Arun District Council
Arun Civic Centre
Maltravers Road
Littlehampton
West Sussex BN17 5LF
Planning & Building Control General Enquiries
Tel: (01903) 737756 Fax: (01903) 716019
Dx: 57406 Littlehampton
Minicom: 01903 732765
e-mail: planning@arun.gov.uk
website: www.arun.gov.uk/planning

15 February 2011

Article 21 of the Town and Country Planning (General Development Procedure) Order 1995
Application for discharge of condition no 14 & 15 in relation to FN/33/10/
Plot B1 Coventry Plantation Horsham Road, Findon,

Site Plan 1:500 @ A3
Findon Travler Site
Plot B1
Coventry Plantation
Horsham Road
Findon
West Sussex
BN14 0RG

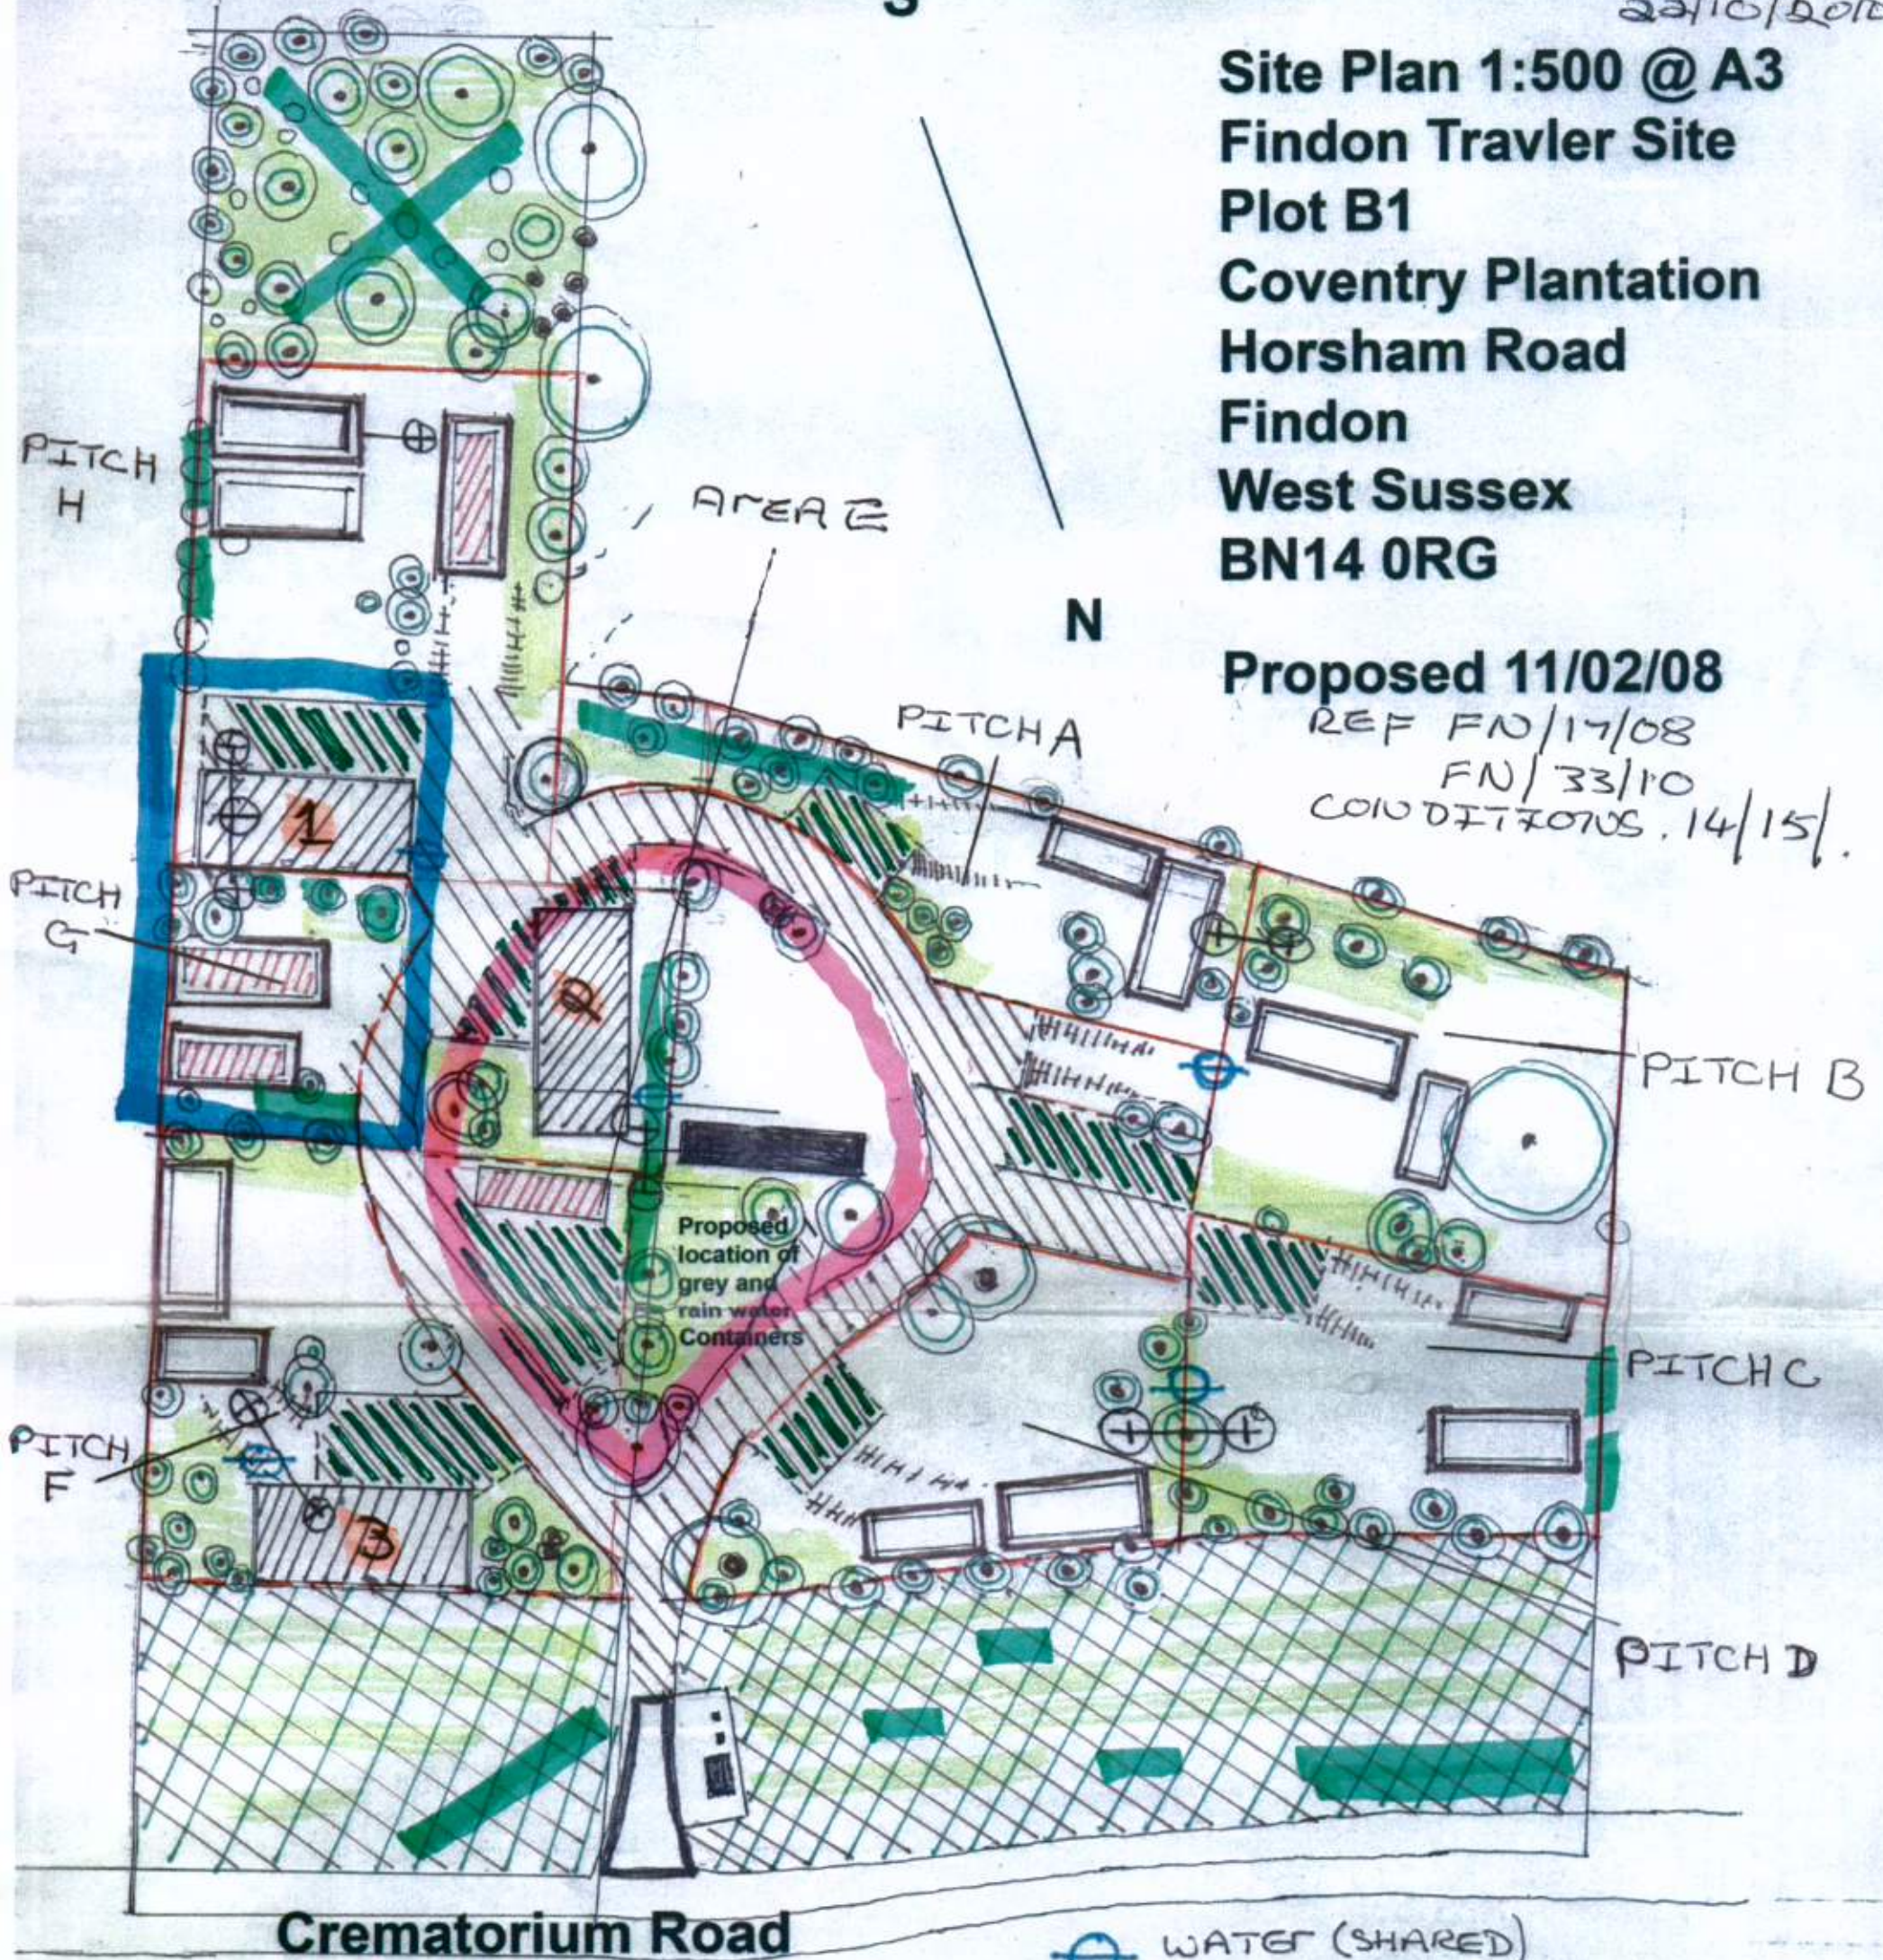
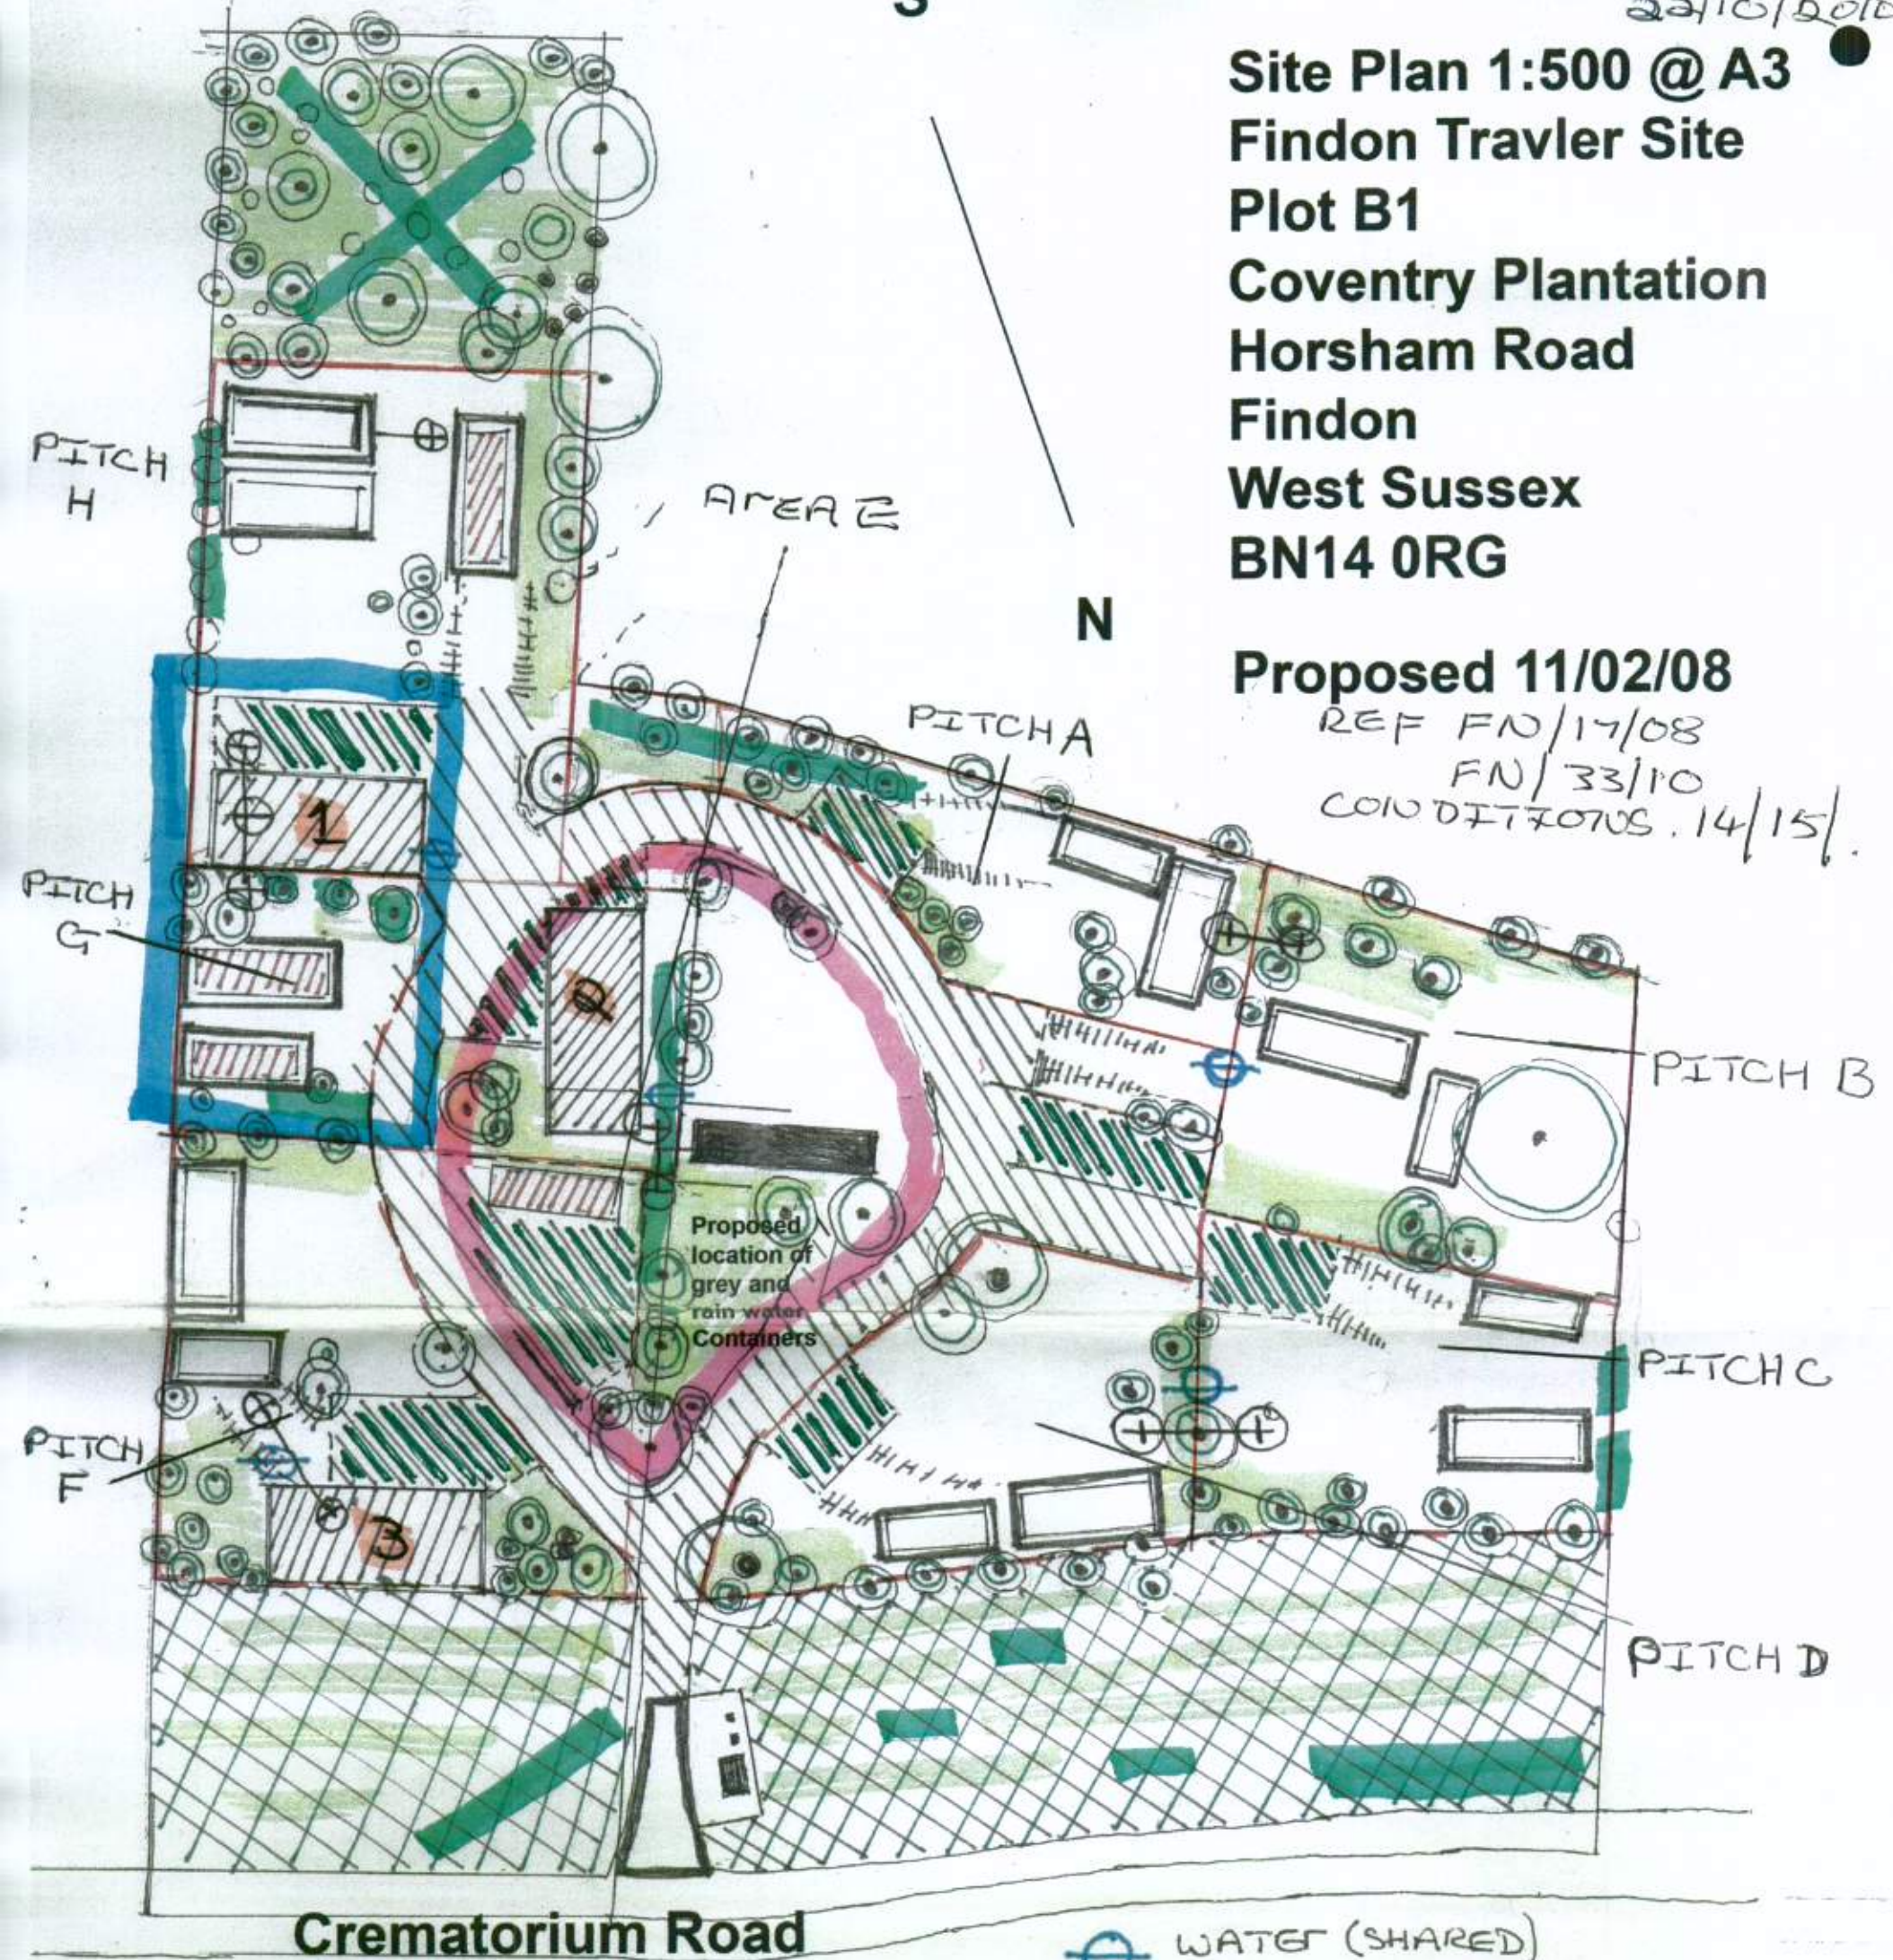
The information submitted is not adequate to discharge the condition. Further details in relation to the management of the 'buffer' strip should be submitted to make specific reference to the need to provide all year round screening to the road.
